About the application

Application number: 2024/90273	
What is the application for?: Erection of two semi detached dwellings	
Address of the site or building:	adj, 53, Garden Place, Dewsbury Moor, Dewsbury, WF13 4EP
Postcode:	S72 8EB

DRAWING TITLE
Site Block Plan
REV 01

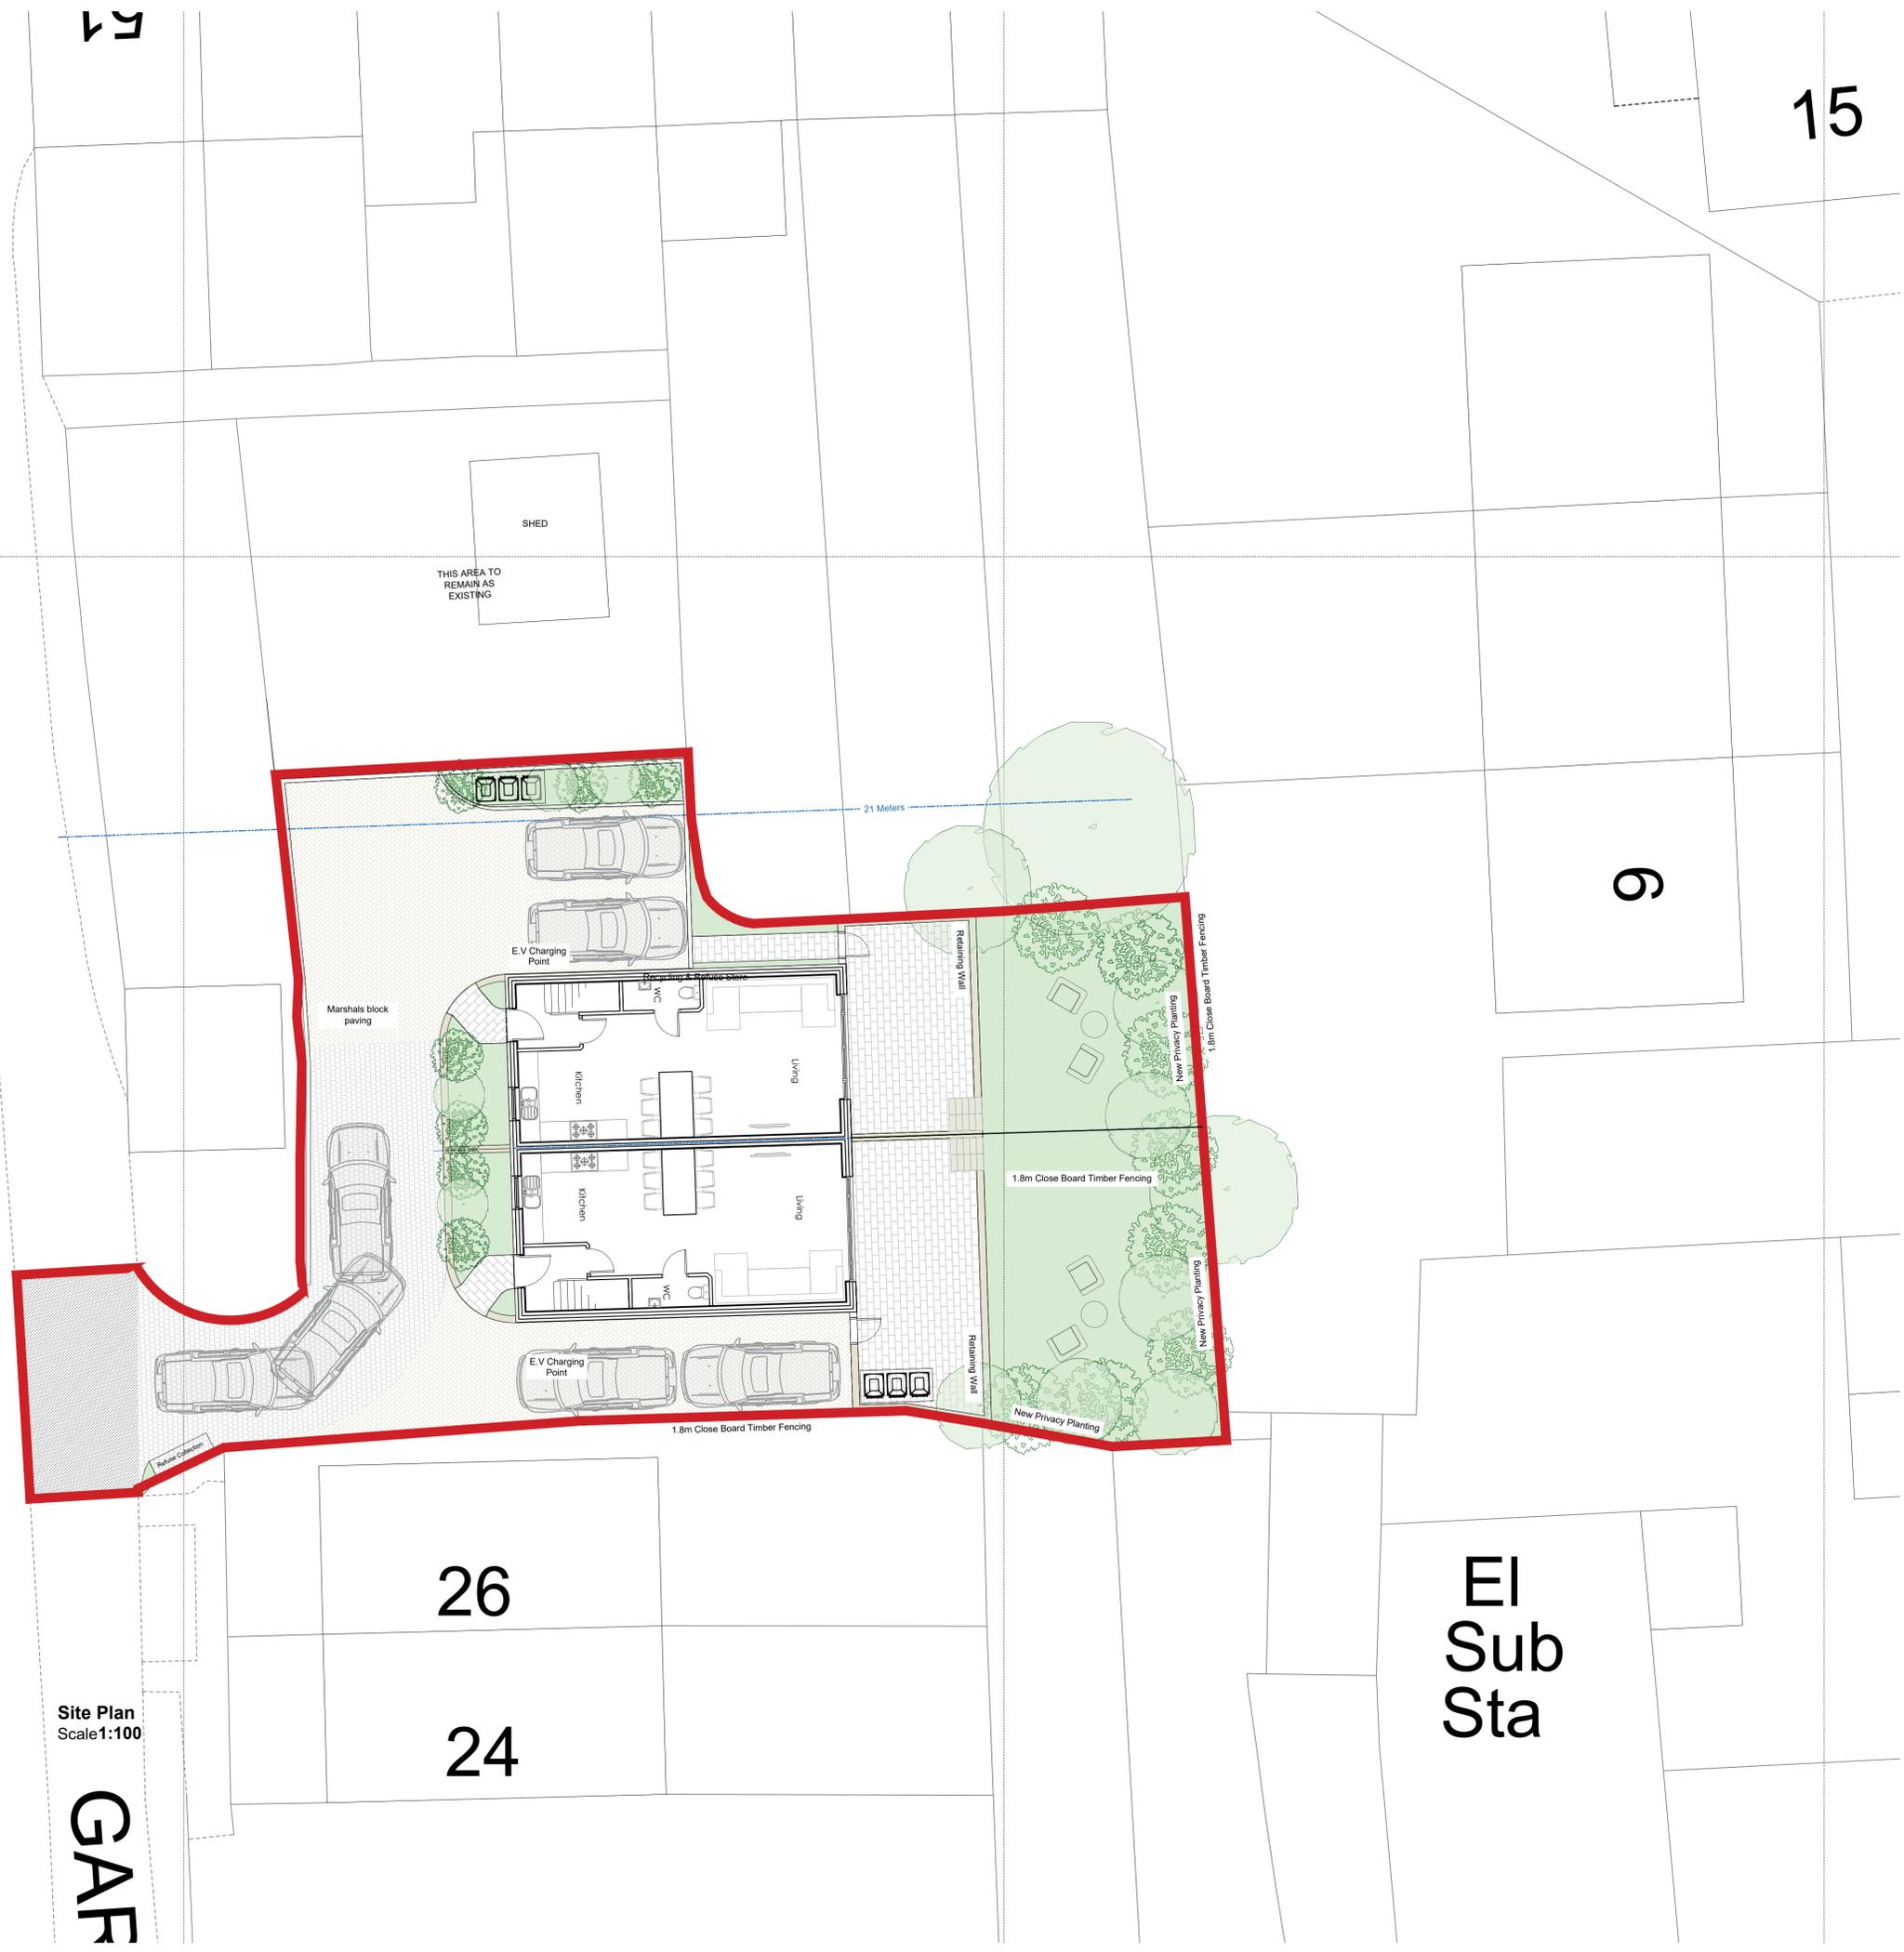
Type of comment: An objection	
Do you wish your comments to be published on the website anonymously?	Yes
This application is significantly over the boundary
